**Sydney Metro State Significant Development, Development Application (SSD DA)
Pitt Street North Over Station Development**

**Appendix C Supplementary Ecologically Sustainable Development and Sustainability Letter
Revision A
Prepared for Pitt Street Developer North Pty Ltd**

**RE: SSD DA Response to Submission (RtS) Supplementary Ecologically Sustainable
Development and Sustainability Letter**

Proposed Updated Design - Roof Perspective

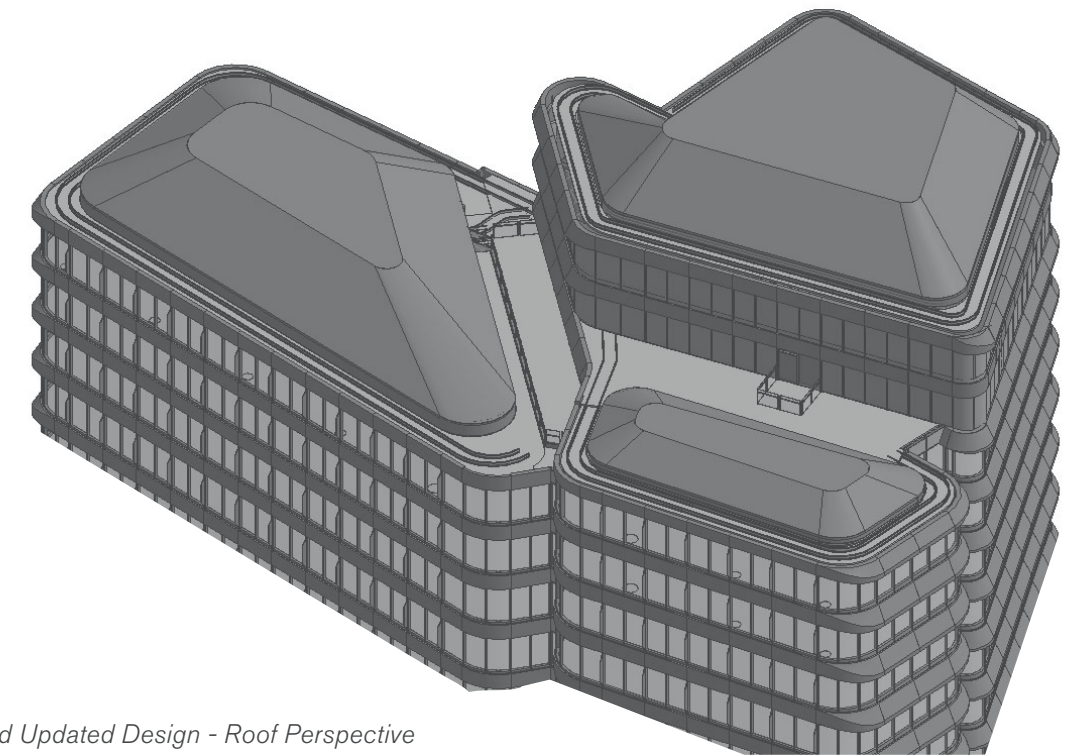
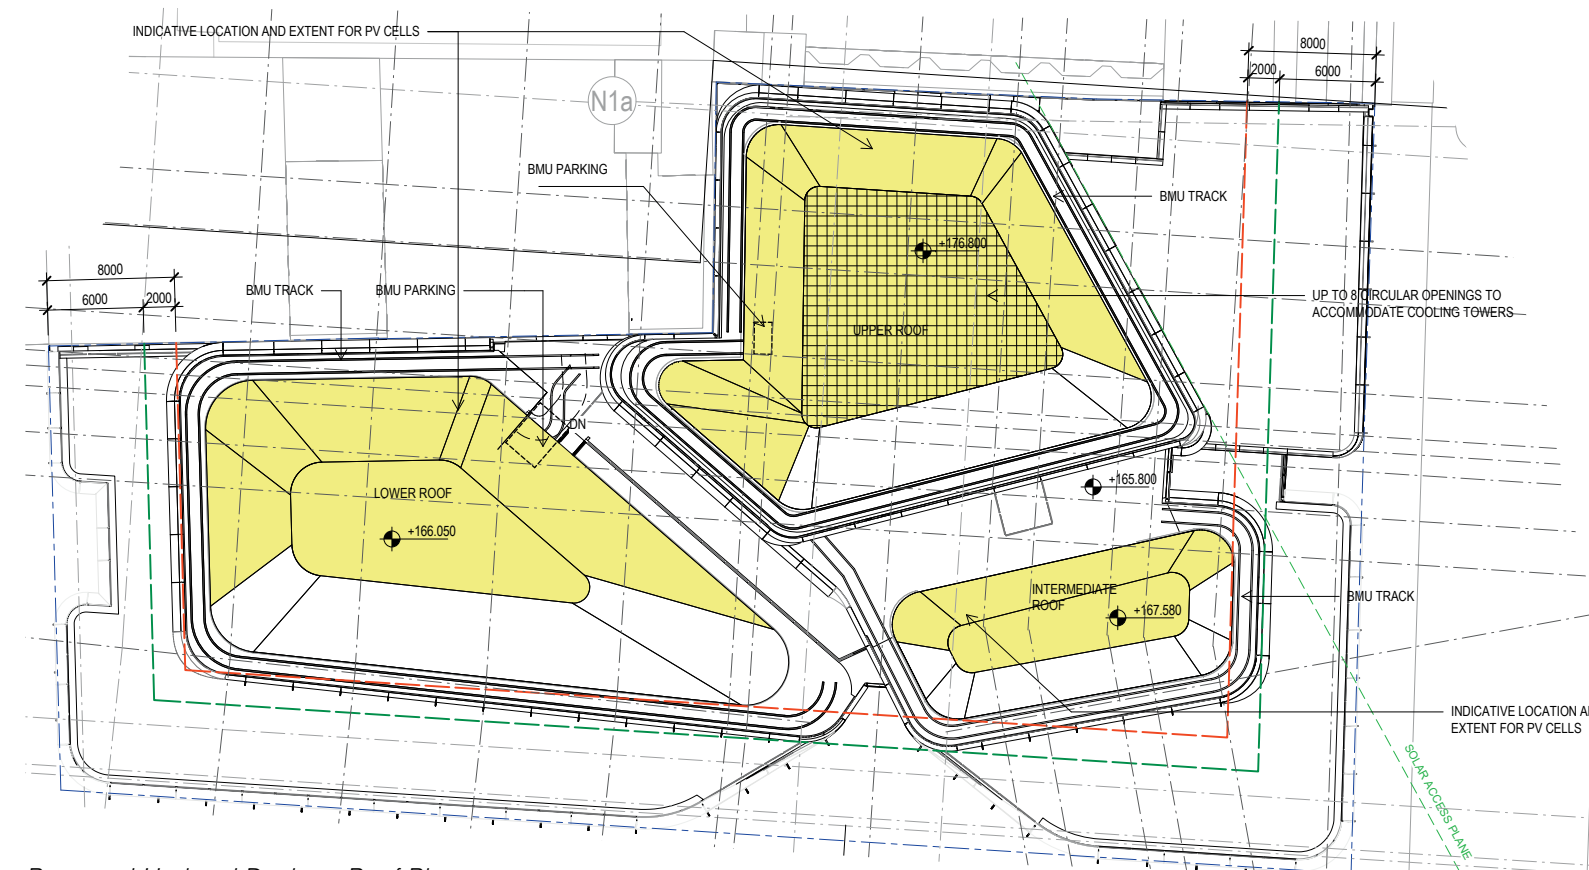
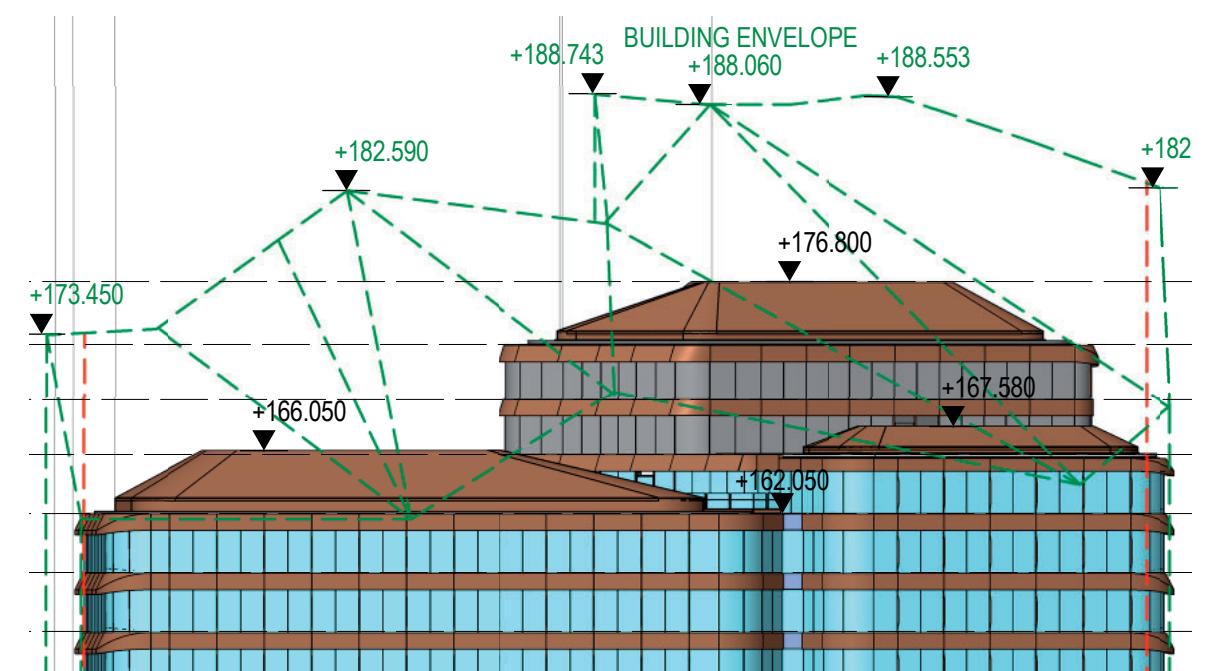
The City requests confirmation about the intentions for 'onsite renewables' as it is not clear in the submitted documentation and the proposed Building Integrated photovoltaics must be marked up on the Architectural Drawings.

The Pitt Street OSD North development is committed to the integration of Solar Photovoltaics (PV) on the roof. The indicative location and extent is shown via Appendix A Revised Architectural Plans and is subject to detailed design development.
